**City of Portland, Maine - Building or Use Permit Application**

<b>Permit No:</b> 08-1373		<b>Issue Date:</b>		<b>CBL:</b> 032 V012001	
<b>Location of Construction:</b> 1 UNION ST (237 Commercial)		<b>Owner Name:</b> 237 COMMERCIAL STREET LLC		<b>Owner Address:</b> 225 COMMERCIAL ST	
<b>Business Name:</b>		<b>Contractor Name:</b> Black Bear Sign		<b>Contractor Address:</b> 137 Rt 1 Scarborough	
<b>Lessee/Buyer's Name</b>		<b>Phone:</b>		<b>Permit Type:</b> Signs - Permanent	
<b>Past Use:</b> Commercial - Retail - "Barbour"		<b>Proposed Use:</b> Commercial - Retail - "Barbour" Install one new 36" x 14" hanging sign		<b>Permit Fee:</b> \$72.00	
<b>Proposed Project Description:</b> Install one new 36" x 14" hanging sign		<b>Cost of Work:</b> \$1.00		<b>CEO District:</b> 1	
		<b>FIRE DEPT:</b> <input type="checkbox"/> Approved <input type="checkbox"/> Denied		<b>INSPECTION:</b> Use Group: Type	
		Signature:		Signature:	
		<b>PEDESTRIAN ACTIVITIES DISTRICT (P.A.D.)</b>

<b>Location of Construction:</b> 1 UNION ST (237 Commercial)	<b>Owner Name:</b> 237 COMMERCIAL STREET LLC	<b>Owner Address:</b> 225 COMMERCIAL ST	<b>Phone:</b>
<b>Business Name:</b>	<b>Contractor Name:</b> Black Bear S

BARBOUR

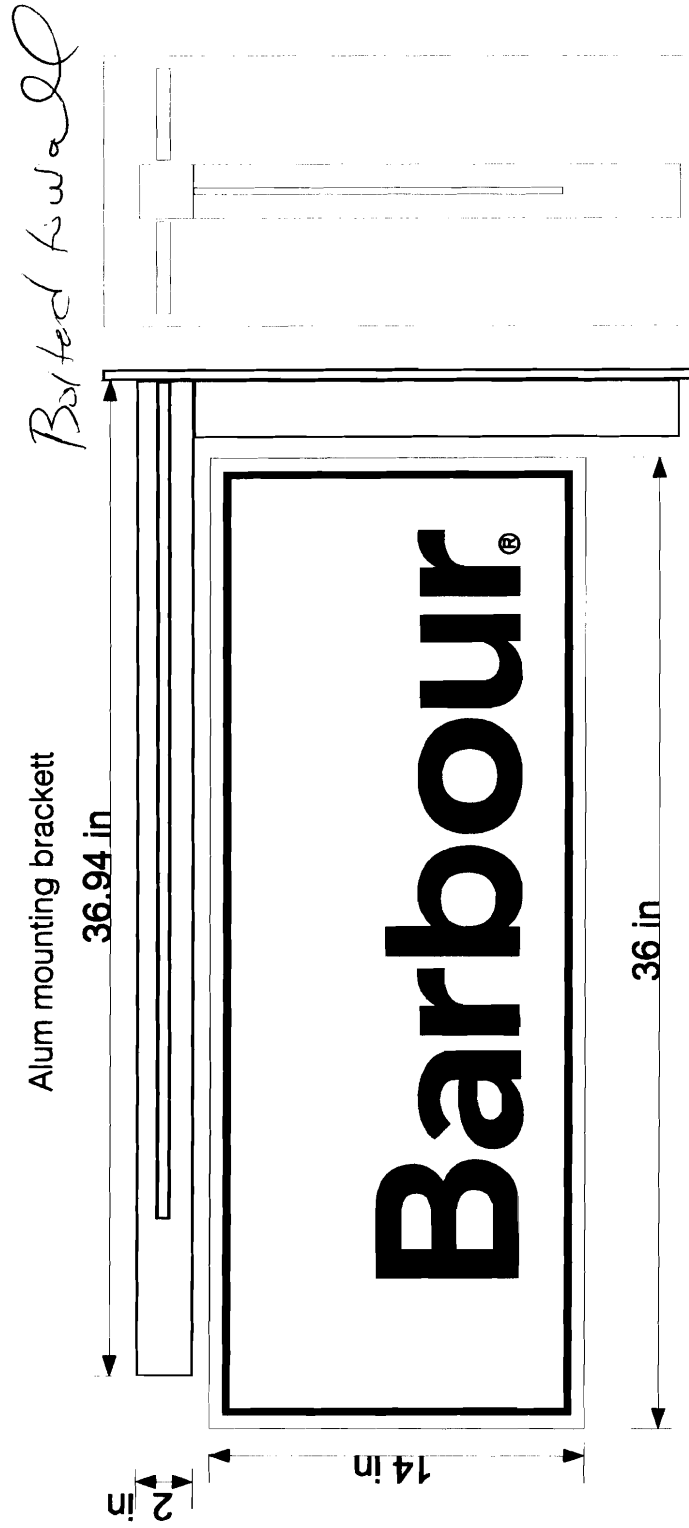
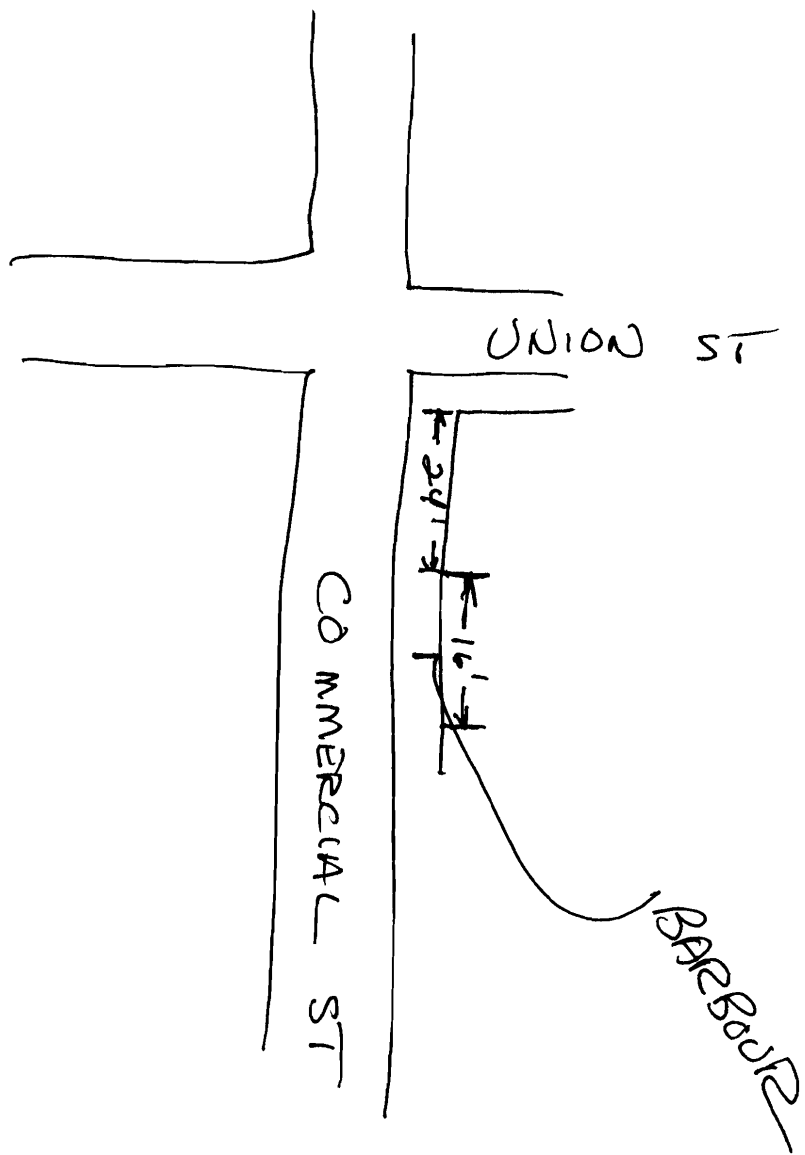
1) \* Sign to be centered over awning, consistent in placement with "McKenzie Tribe" sign on adjoining storefront.

\* Existing holes in granite fascia to be infilled with granite dust/epoxy to restore original appearance.
